Application Ref: 79843/APP/2025/3245

REFUSAL OF PLANNING PERMISSION

Site location: 4 Albany Close Ickenham UB10 8QW

Description:
Erection of first floor extension and associated alterations to allow for part-conversion of roof space to habitable use

1 Front Elevation (North)

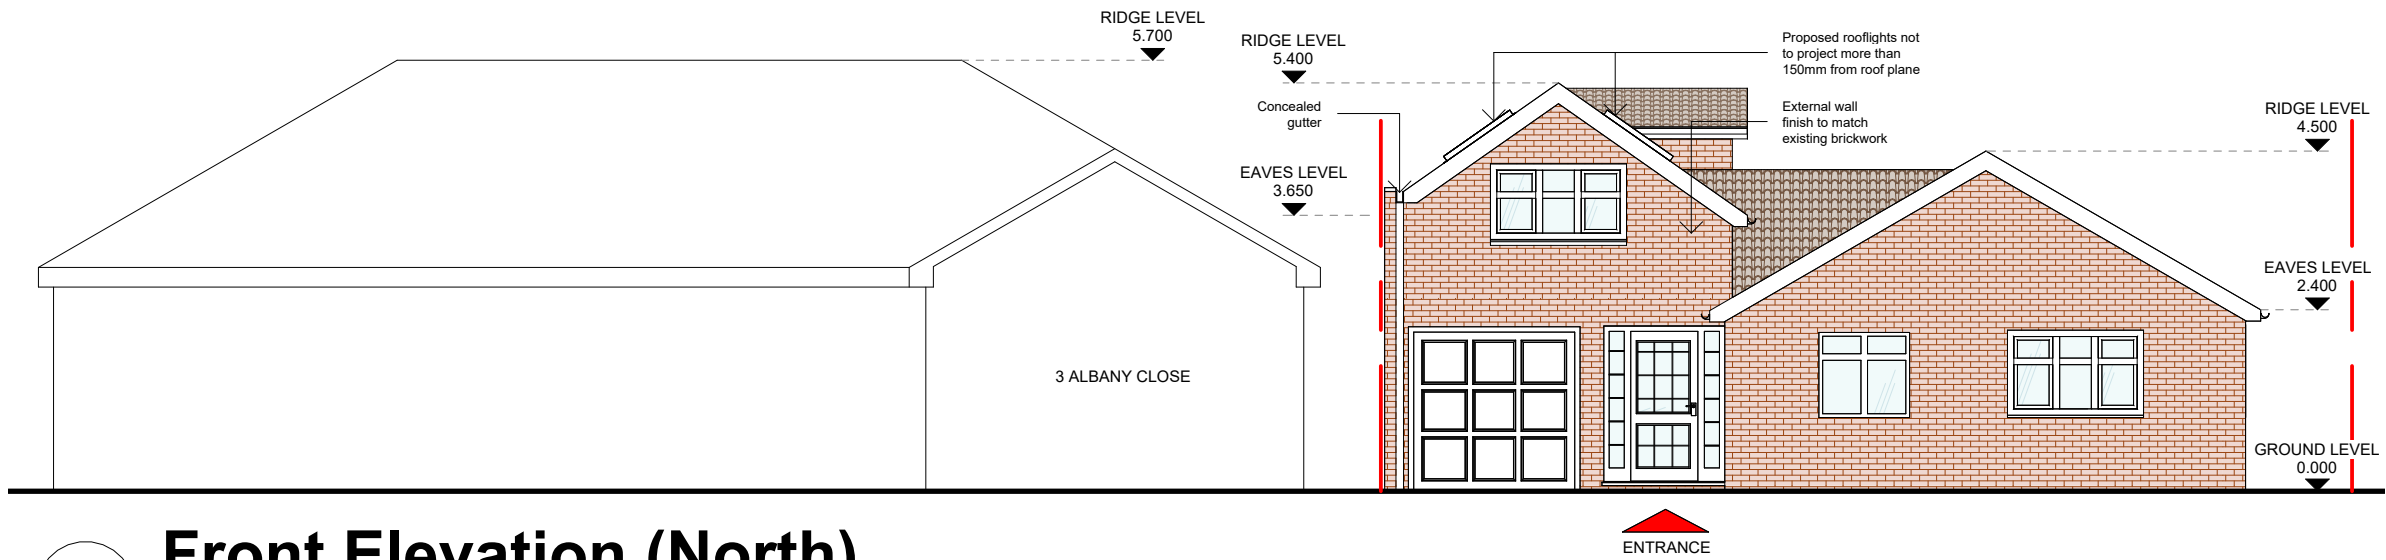
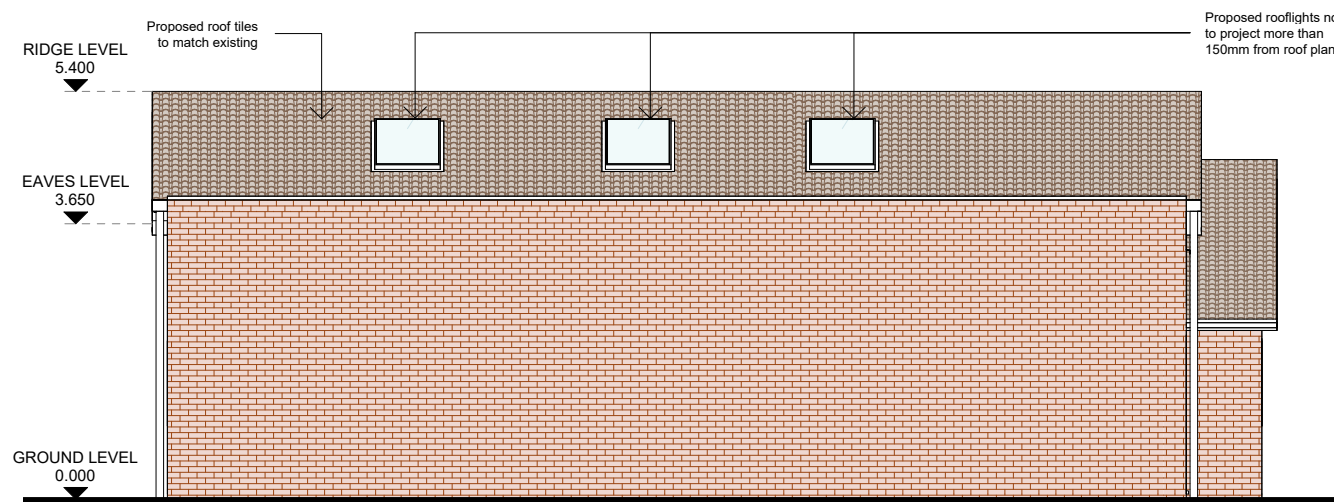
1. The proposed development, by virtue of its size, siting, form and design, would result in a disproportionate and unsympathetic addition to the property which would fail to appropriately integrate with the dwelling or the immediate surrounding built form of the Conservation Area. The first floor extension would fail to appear as appropriately subservient which, together with the unsatisfactory design, would result in the extension appearing as a disagreeing and discordant addition, and would introduce an uncharacteristic feature to the Close, diluting the existing uniform character exhibited. Furthermore, the immediate proximity of the extension to the side boundary at first floor level would also result in a visually cramped appearance, over and above what currently exists at the site, to the detriment of the visual amenities of the area. Overall, the proposal would

3 Rear Elevation (South)

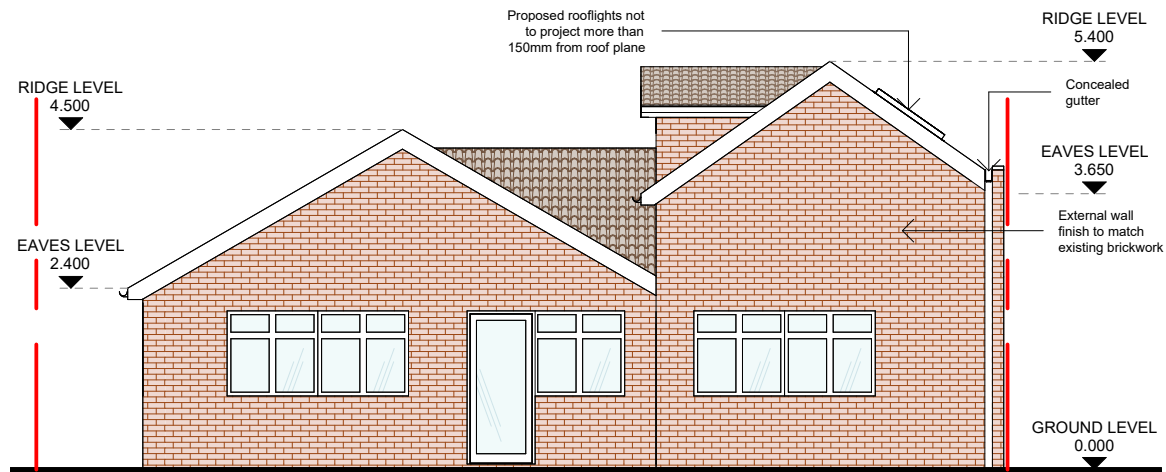
2. The proposed first floor rear opening, by virtue of its siting, height, openable nature and the limited separation distances involved, would result in the introduction of a harmful level of overlooking to the rear of the site, significantly impacting upon the privacy of an adjacent neighbour, namely no. 40 Halford Road. As such, the proposal would represent an un-neighbourly form of development which would not achieve a satisfactory relationship with adjacent dwellings, failing to preserve the amenity of a neighbouring property. The proposed development would therefore not conform to the requirements of Policies DMHB 11 and DMHD1 of the Hillingdon Local Plan: Part Two - Development Management Policies (2020).
